Ribble Valley Borough Council
Church Walk,
Clitheroe,
BB7 2RA

Phone: 0300 123 6780
Email: lhscustomerservice@lancashire.gov.uk
Your ref:
Our ref: LHS/CS/3/2016/0374
Date: 9th June 2016

Proposal:	Erection of 9 dwellings and associated works
Location:	Land to the East of Clitheroe Road Barrow BB7 9BN
Grid Ref:

Street scene along Site Entrance (Section B-B)

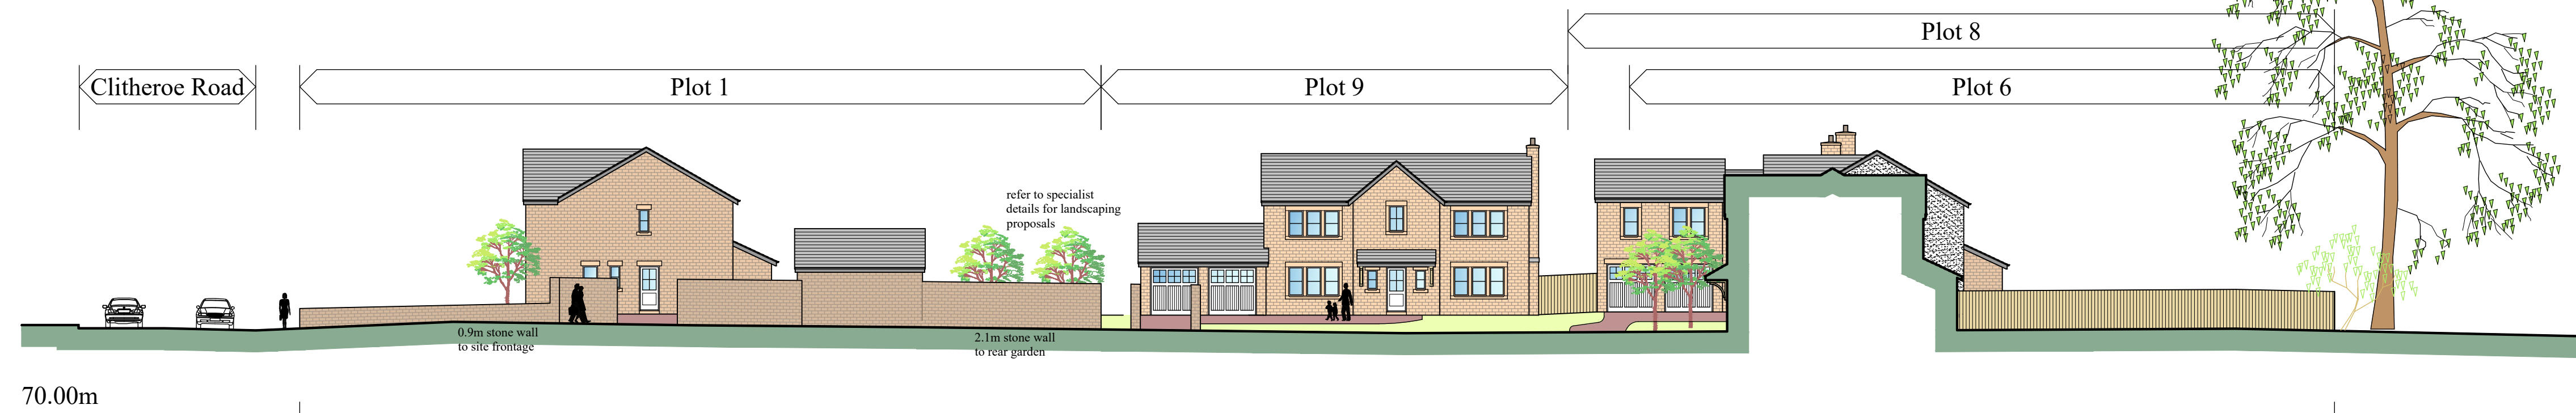
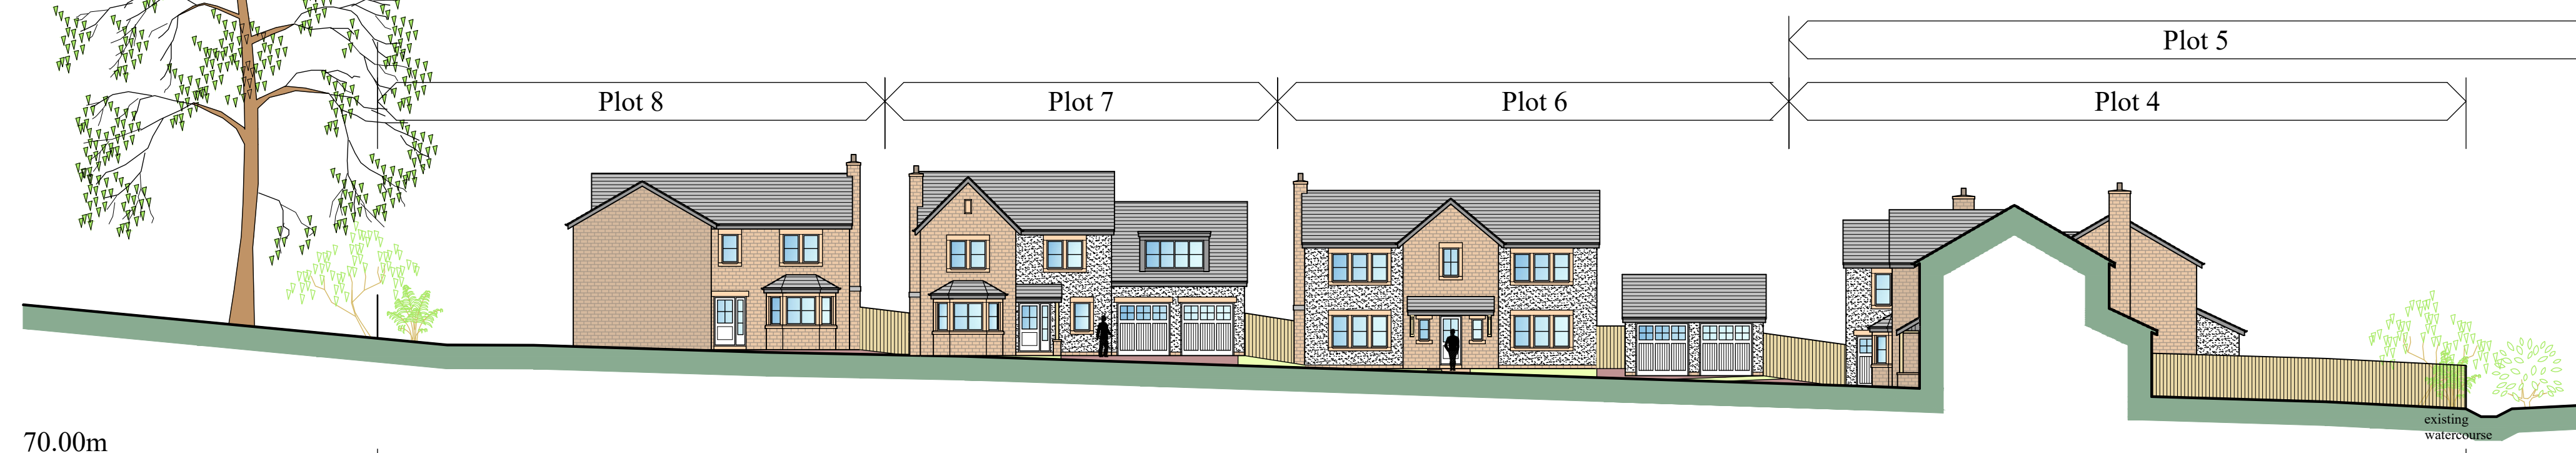
The Highway Development Control Section is of the opinion that the shown sight lines of 2.4x60m are acceptable in this location due to the width of Clitheroe Road (approx. 8.35m) and the achievable sight lines to the north are greater than show.

The Highway Development Control Section is of the opinion that the applicant should prove the site access with Clitheroe Road for a twin axel refuse vehicle when a car is in the opposite lane of the access. Alternatively provide a prescribed access with a 5.5m wide road for a minimum of 10m into the site with 6m radius on both sides of the access

3. No part of the development shall be commenced until the visibility splays measuring 2.4 metres by 60 metres in both directions to be provided, measured along the centre line of the proposed new road from the continuation of the nearer edge of the existing carriageway of Clitheroe Road, to the satisfaction of the Local Planning Authority. The land within these splays shall be maintained thereafter, free from obstructions such as walls, fences, trees, hedges, shrubs, ground growth or other structures within the splays in excess of 1.0 metre in height above the height at the centre line of the adjacent carriageway.
Reason: To ensure adequate visibility at the street junction or site access in the interest of highway safety in accordance with Quality of Development Policy and Transport Policy in the Local Plan.
